Epping to Thornleigh Third Track Proposal. Application number SSI 5132.

~~4~~we object to the Epping to Thornleigh Third Track Proposal and consider that the EIS is inadequate and does not address the full impact of this proposal. It will cause untold damage to the health of residents and to the fabric of the Beecroft Cheltenham Heritage Conservation Area. Do not approve this project, reconsider the alternatives and protect the community.

Figure S.6 Cross-section and elevation - New Cheltenham Station concourse building (see also S.5 for artist's impression)

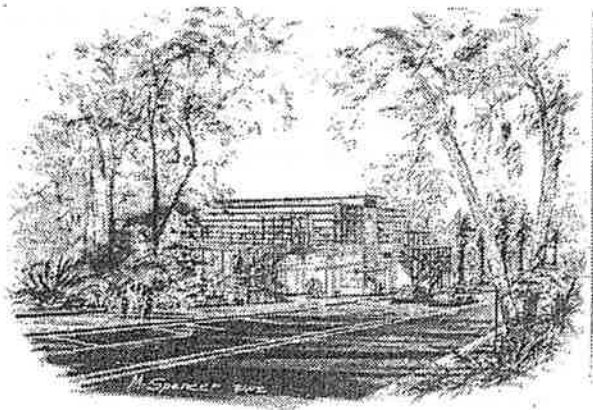
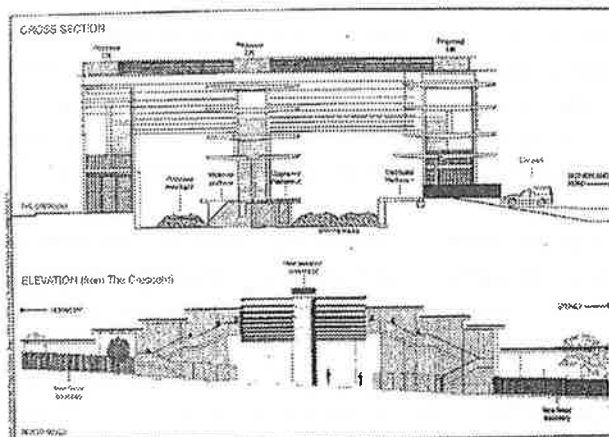
- The proposed replacement of Beecroft Station shows no regard for the HCA. The visual impact of the proposed 13m high glass and steel concourse is totally unacceptable in this HCA.

Figure 5.3 Future Cheltenham Station layout

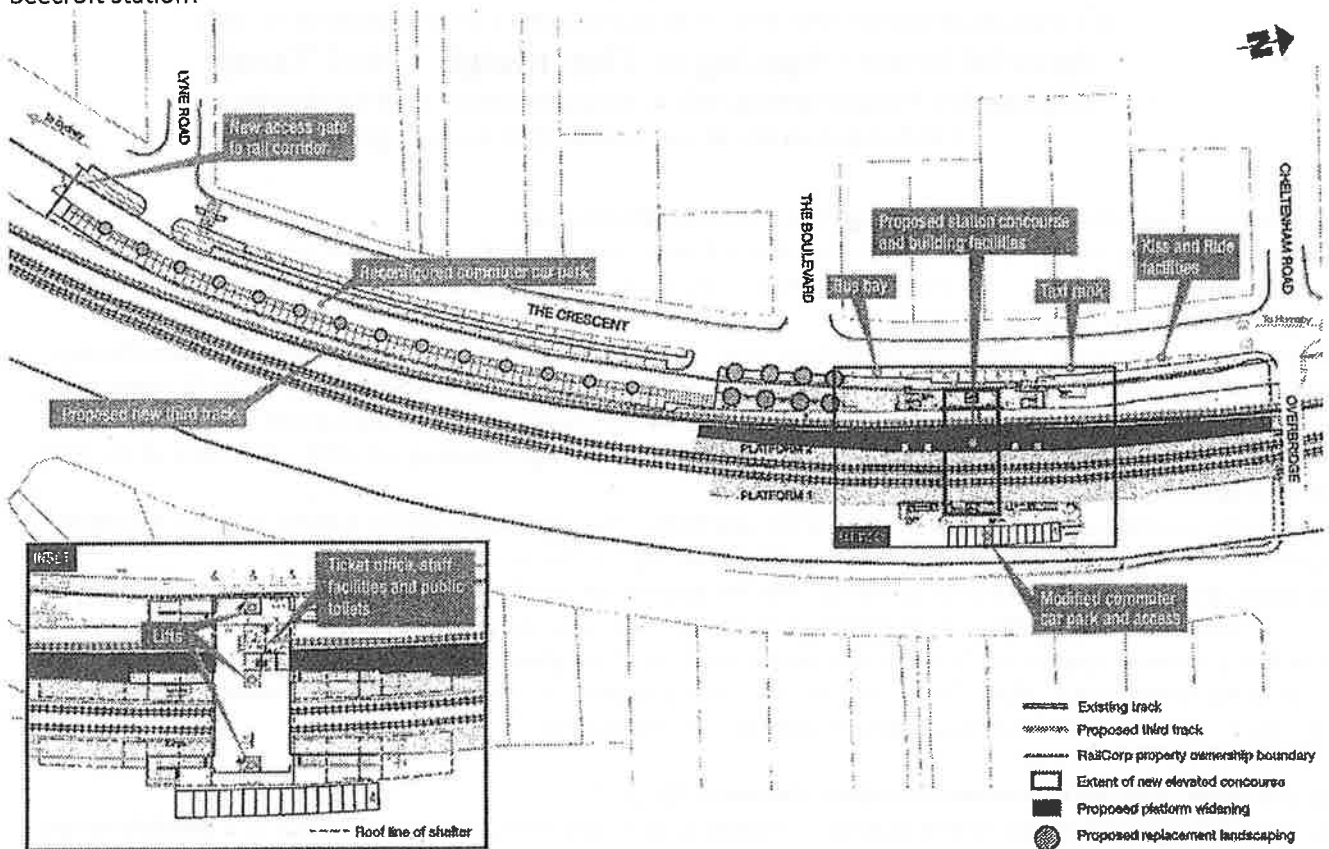
- There has been inadequate assessment of the project's impact on the fabric of the Beecroft Cheltenham Heritage Conservation Area (HCA).
- The plan for Beecroft Railway station Precinct is vague. The relationship to the trees, playground and original form located south of the present station is not shown. A fourth track is shown on the eastern side but does not include urgently needed lifts to allow disabled access at Beecroft Station.
